Your reference: DOC12/3676
Our reference: 10/2188_06_0184 Mod 3
Contact: John Coffey

Pasminco Cockle Creek Remediation (06_0184 Mod 3)

ATTACHMENT 1 – Comments

Figure 1: Concept of proposed geocomposite capping system

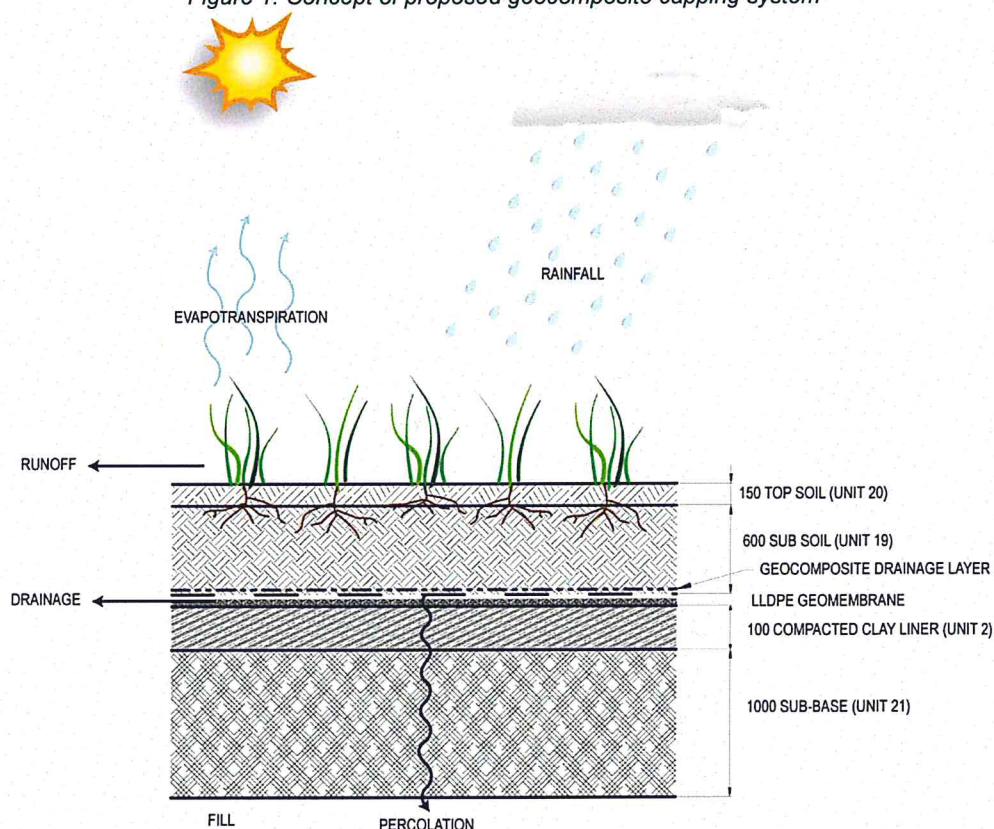
The use of LLDPE as a cell barrier material is very commonly backed up by an effective secondary clay barrier, for which the clay layer would be in the range of 500 to 1000 mm. So while there is a clay layer, we consider the thickness of only 100 mm thickness provides mainly a protective bedding material rather than a secondary barrier layer.

Accepting that one of the objectives of this amendment is to increase the storage volume of the cell by reducing the thickness of the clay barrier by 500 mm, we consider that the barrier performance of the cell capping is now totally dependent on the LLDPE. To have an appropriate level of barrier protection with this design, with only the underlying 100 mm of clay, the EPA recommends that the LLDPE barrier should be a minimum thickness of 1.5 mm.

The use of geocomposites for this function is widely practised and accepted by the EPA. Based on our experience of the use of geocomposites in such service the EPA recommends that:

1. proposed geocomposite drainage system must provide equivalent hydraulic transmissivity to the currently approved gravel layer;
2. the geonet must be tri-planar high density polyethylene, manufactured or covered with a geotextile fabric on the upper surface;
3. the thickness of the internal drainage core of the geonet must be minimum of 10mm, and
4. to ensure the effectiveness of the drainage pipes system, they be positioned in an invert in the LLDPE barrier system as suggested by the applicant or an equivalent system.

For these reasons the EPA considers the level of protection of the proposed LLDPE barrier layer is not adequate and needs to be increased. To achieve this, the EPA recommends amendments to the top and subsoil layers above the LLDPE:

1. An increase in the total thickness of topsoil and subsoil above the geocomposite drain and LLDPE barrier by 250 mm, taking the total thickness from 750 mm to 1000 mm; and
2. That at no less than 250 mm above the geocomposite drain and LLDPE barrier a high visibility marker mesh layer be placed across the cell cap; or
3. an equivalent increase in the protection of the LLDPE barrier layer be provided.

- An LLDPE liner thickness of a minimum of 1.5 mm;
- Protection of the LLDPE barrier layer be improved by;
 - increasing total thickness of topsoil and subsoil layers above the geocomposite drain and LLDPE barrier to 1000 mm;

- placement of a high visibility marker mesh across the LLDPE capped portion of the cell at no less than 250 mm above the geocomposite drain and LLDPE barrier. The marker mesh must not impede the functioning of the capping system; **or**

- by an equivalent enhancement to the protection of the LLDPE barrier layer
- A geonet drainage layer above the LLDPE liner must be; minimum tri-planar, of high density polyethylene and manufactured or covered with a geotextile fabric on the upper surface. The thickness of the internal drainage core of the geonet must be minimum of 10mm.

- Confirmation that the hydraulic transmissivity of the geocomposite/geonet system is at least equivalent to the hydraulic transmissivity of the currently approved gravel drainage system.

- **drainage pipe system above the LLDPE liner designed to maximise water collection with placement of pipes. In proposed inverts or similar.**
